Addendum No. 1

RE: Contract ID: C201010
WBS # 34885.3.2
F.A. # STP-0620 (12)
Cumberland County (U-2912)
Owens Drive Extension From I-95 Business
To NC-87 at SR-2283 (East Mountain Drive)
In Fayetteville.

November 16, 2004 Letting

PROJECT REFERENCE NO. U-2912 SHEET NO. 10  
 R/W SHEET NO.  
 ROADWAY DESIGN ENGINEER SEAL 14493  
 HYDRAULICS ENGINEER SEAL 12786

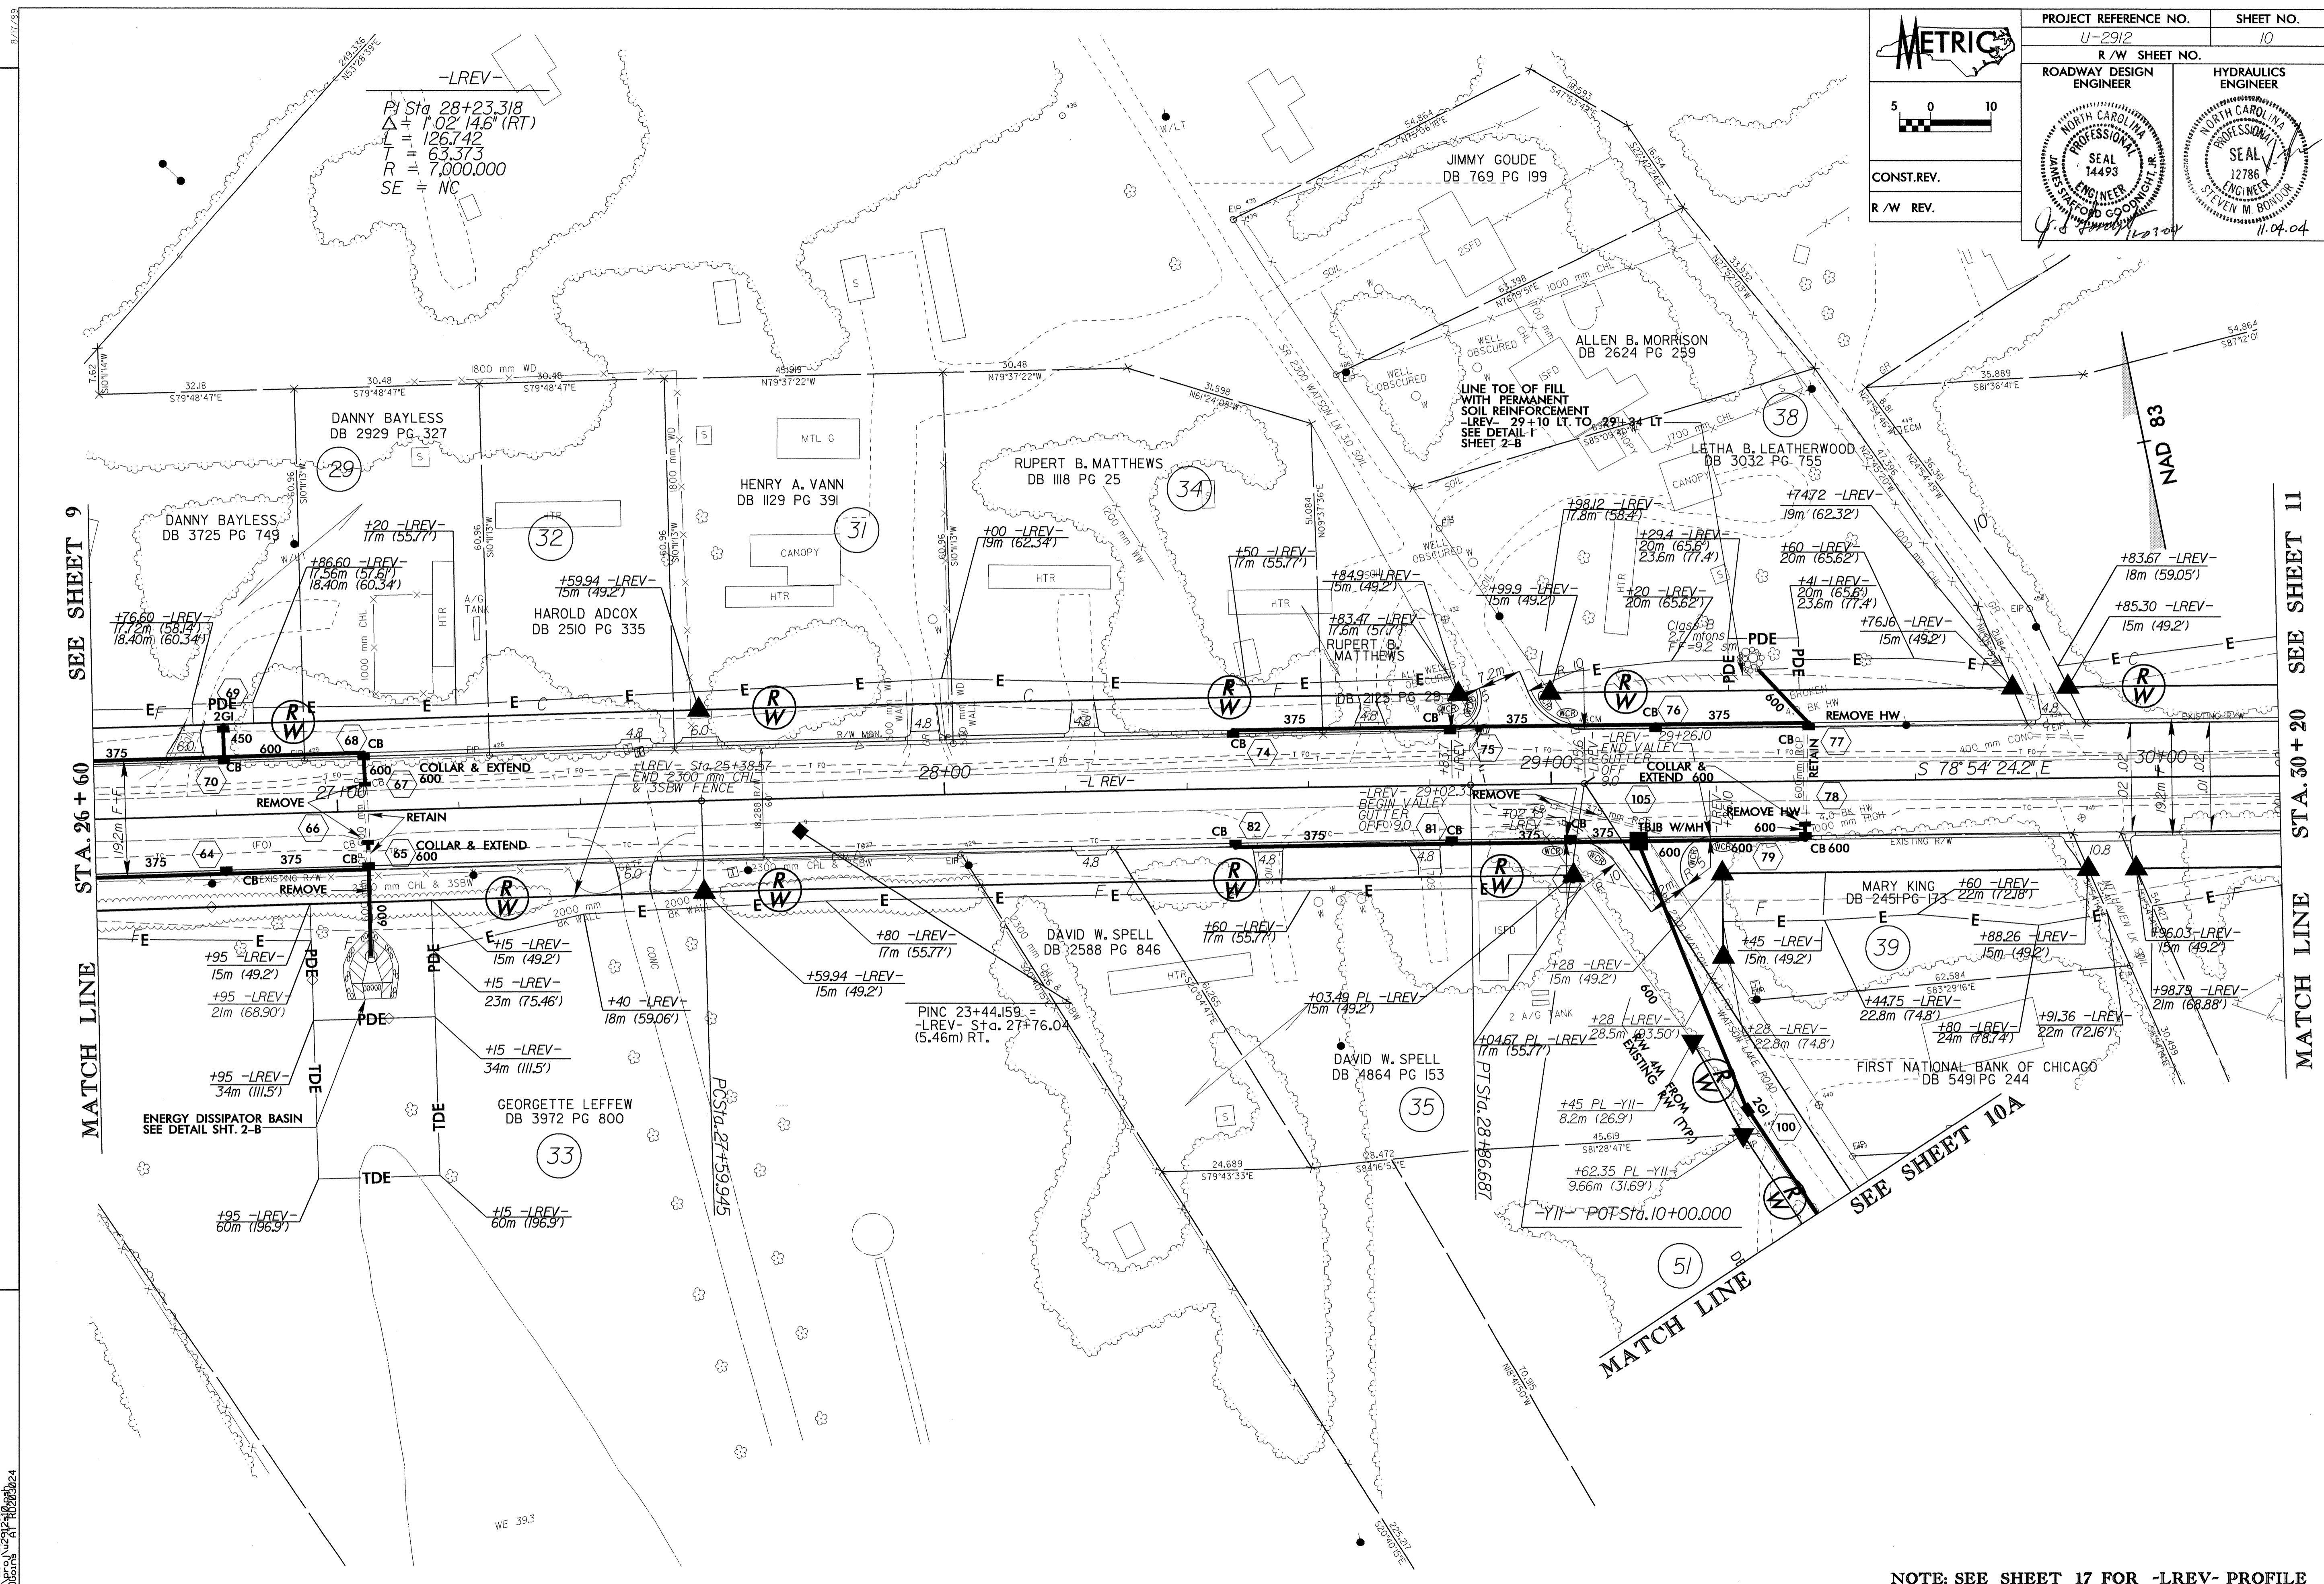
Sheet No. 10 has been revised to show the location of "Concrete Valley Gutter." Please void Sheet No. 10 in your plans and staple the revised Sheet No. 10 thereto.
